PLANNING AMENDMENT

H17/0344/00

ERECTION OF BOARDING KENNELS

Amendment: Amend kitchen and fencing
Dwg. No. RDH.01 B

G.R. MERCHANT.	DRAWING No.: RDH. 01 C
----------------	------------------------

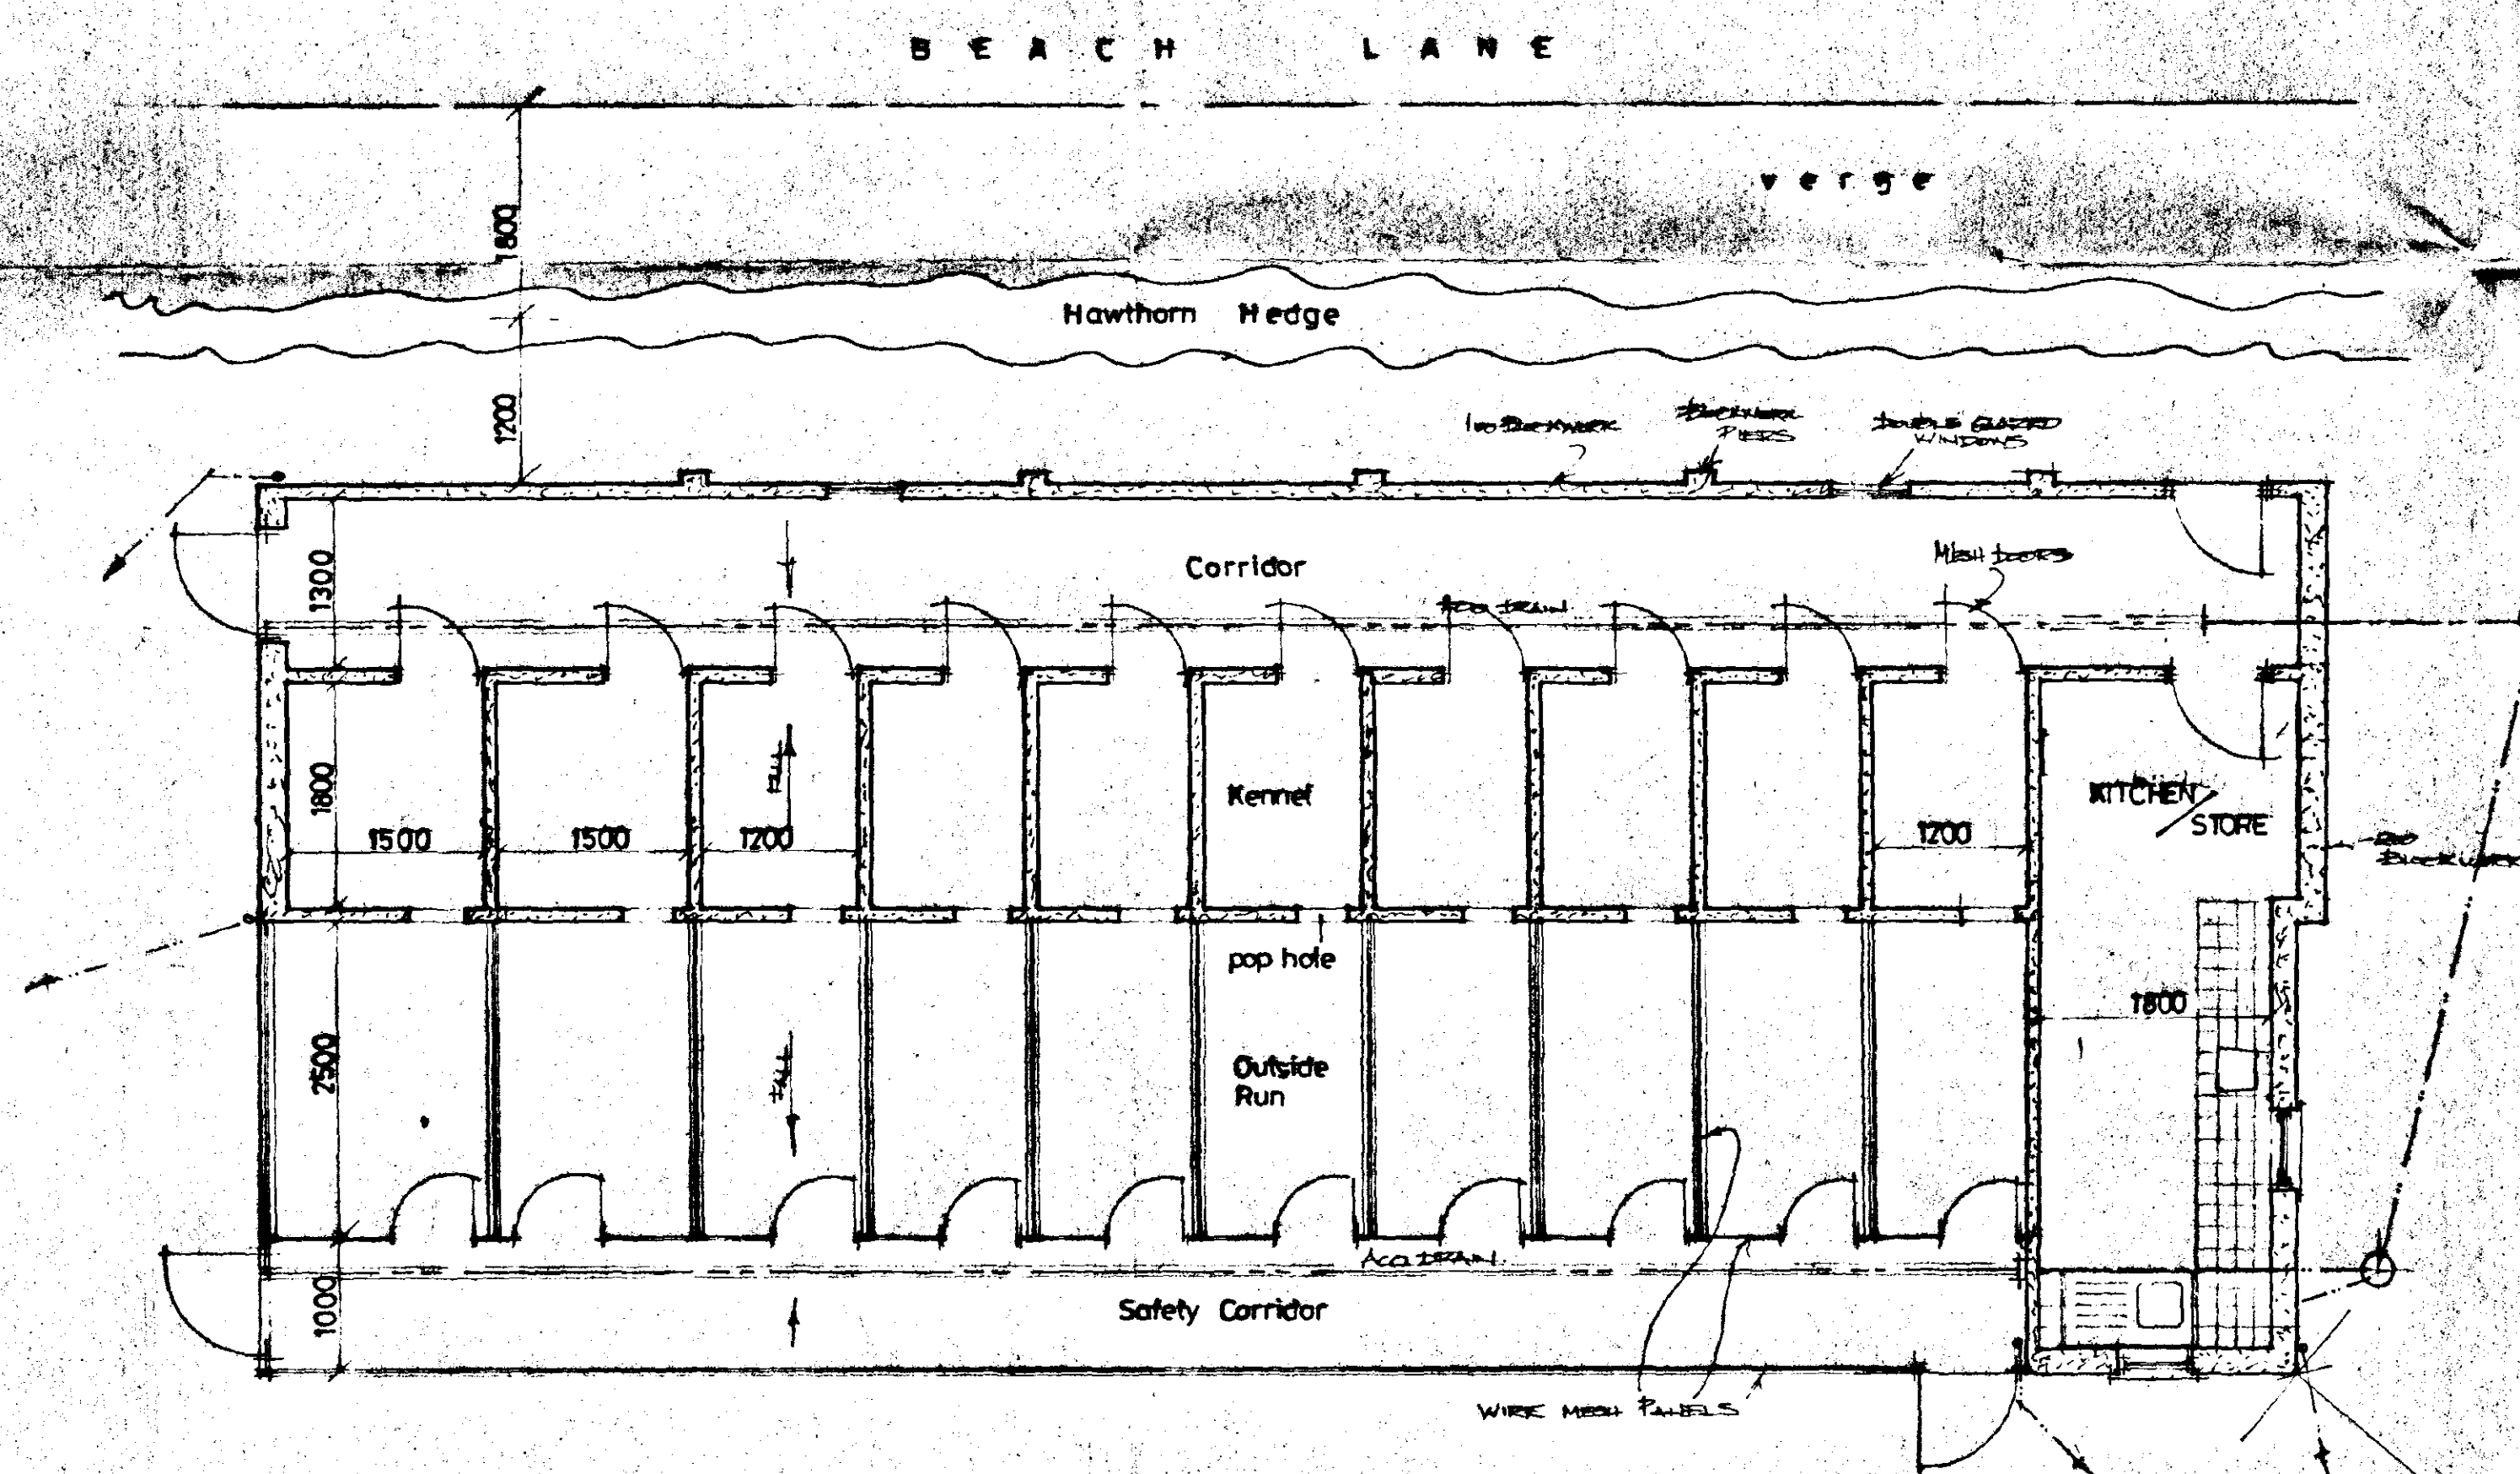
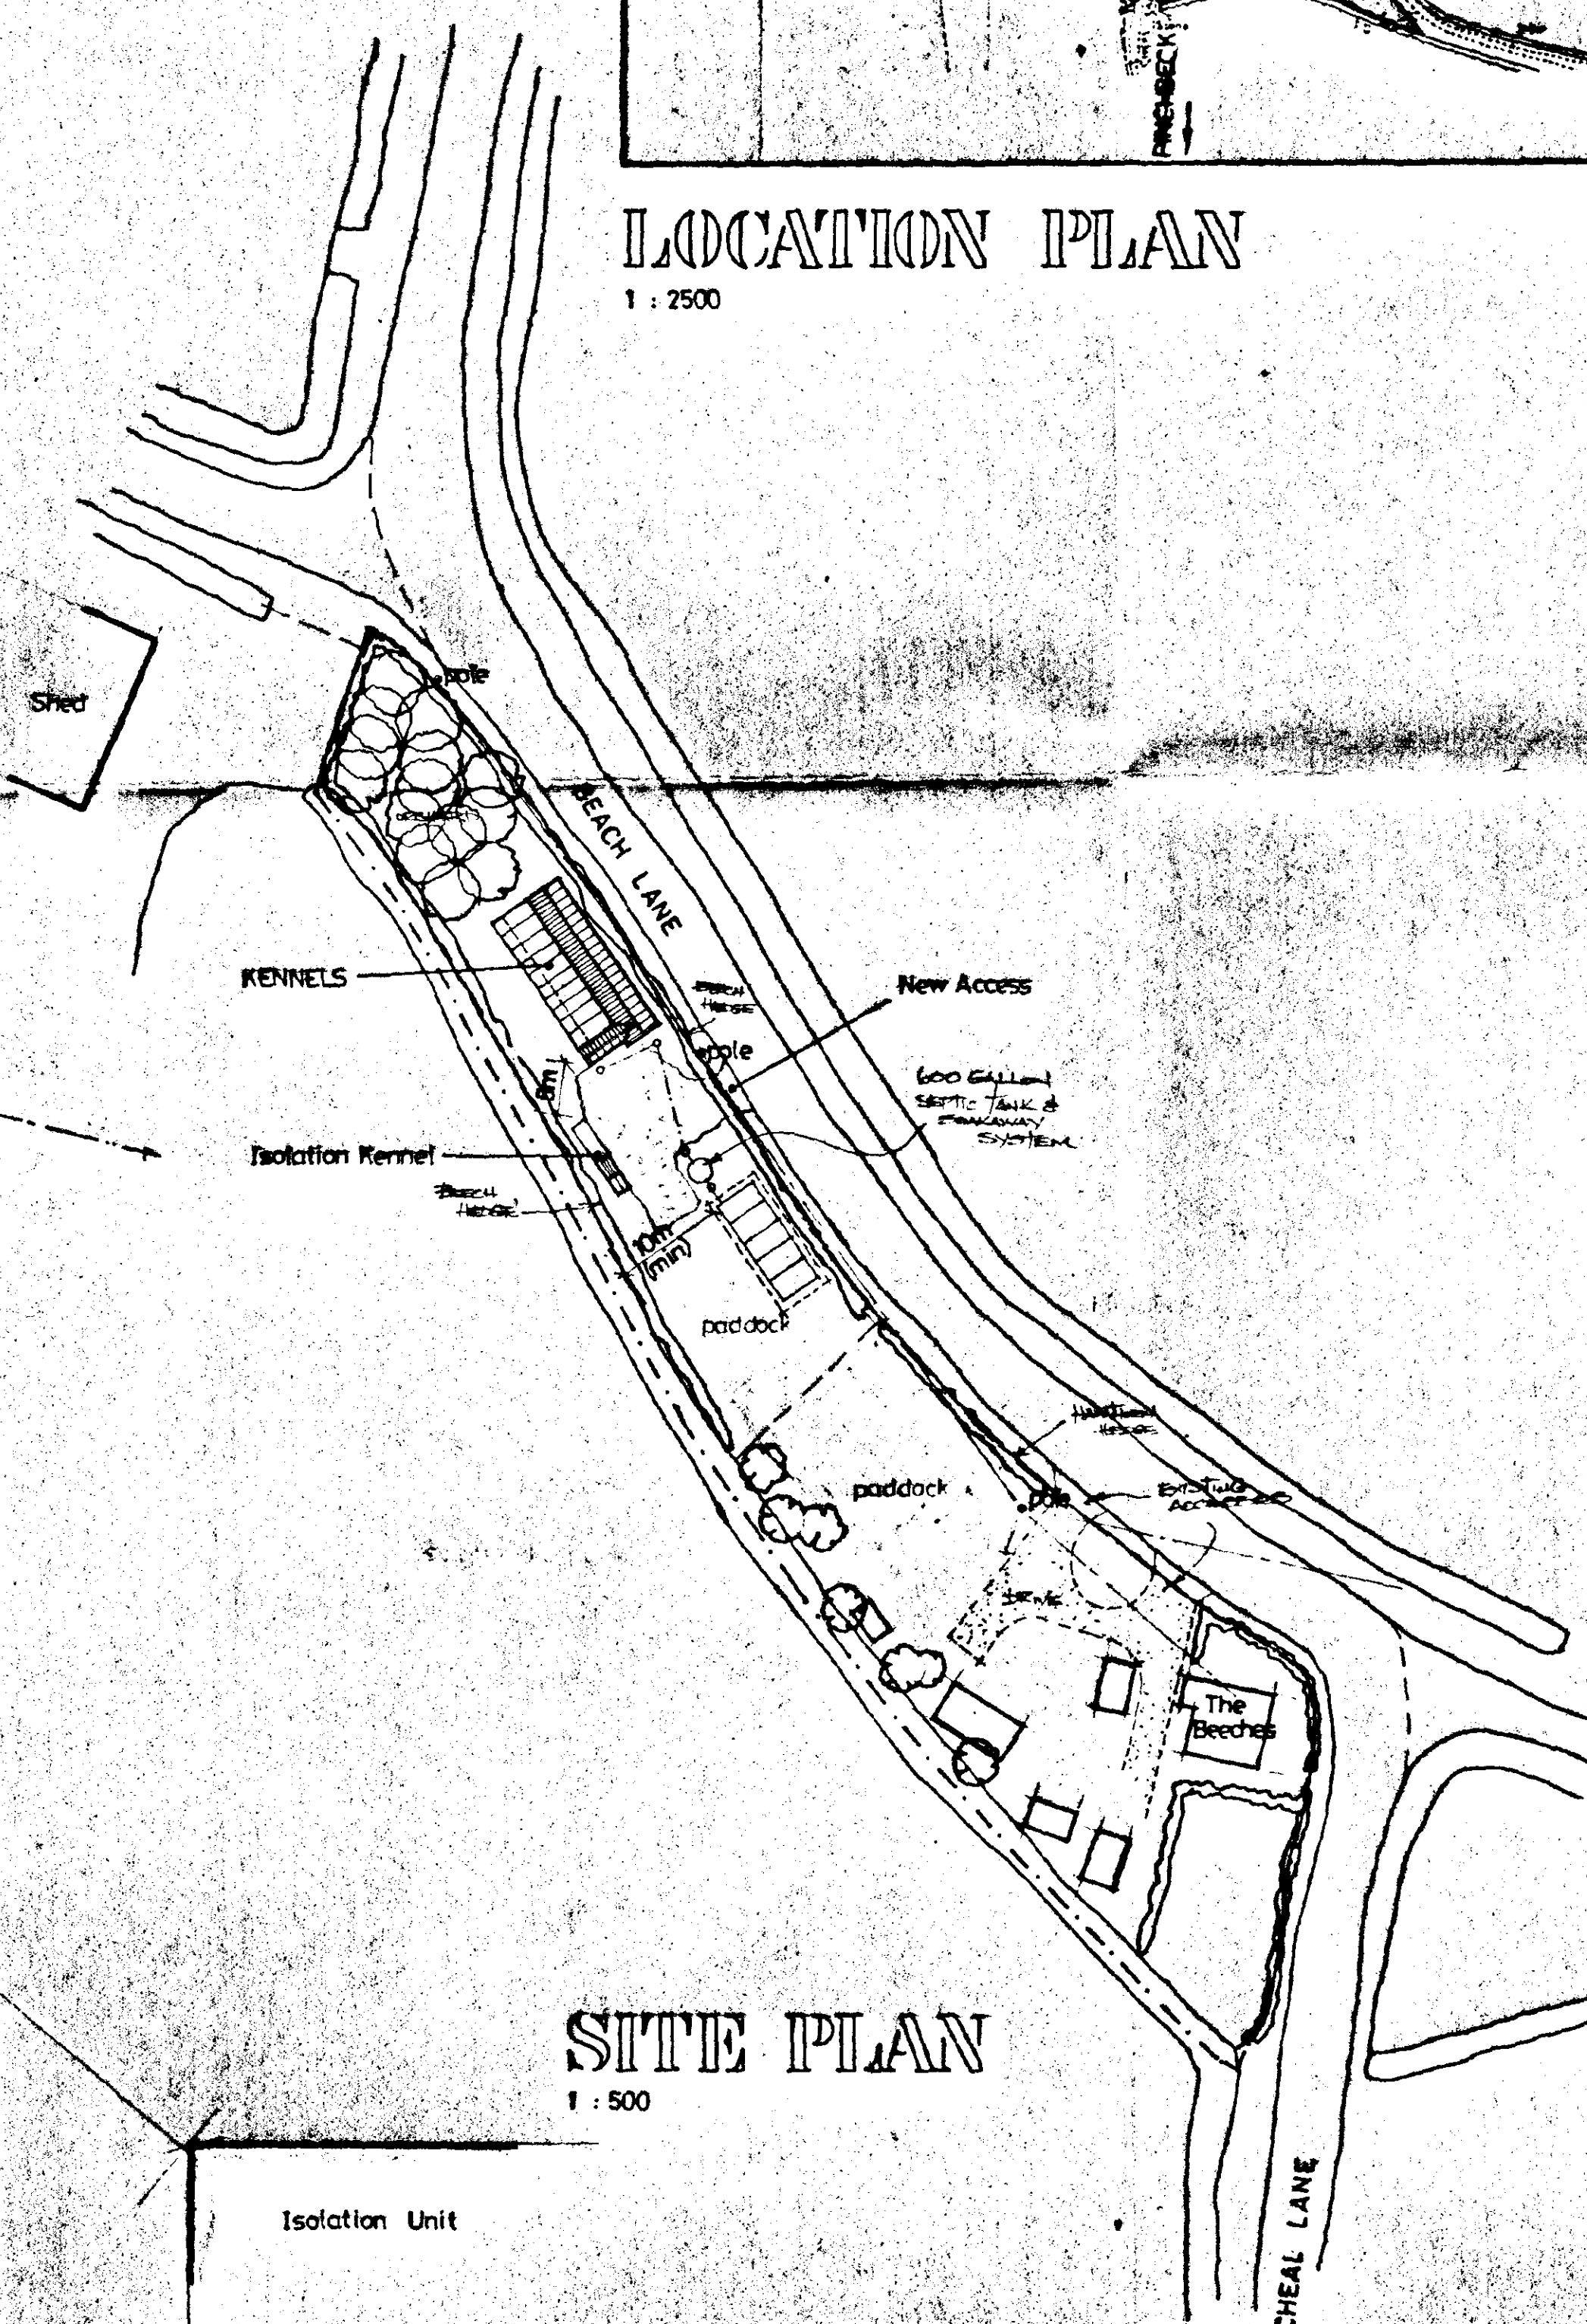
ENLARGED KITCHEN & FENCING
AFTER DISCUSSIONS WITH
TOWN CHAMBERS and
ENVIRONMENTAL HEALTH
DEPT.

RE-SITE REPAIRS.
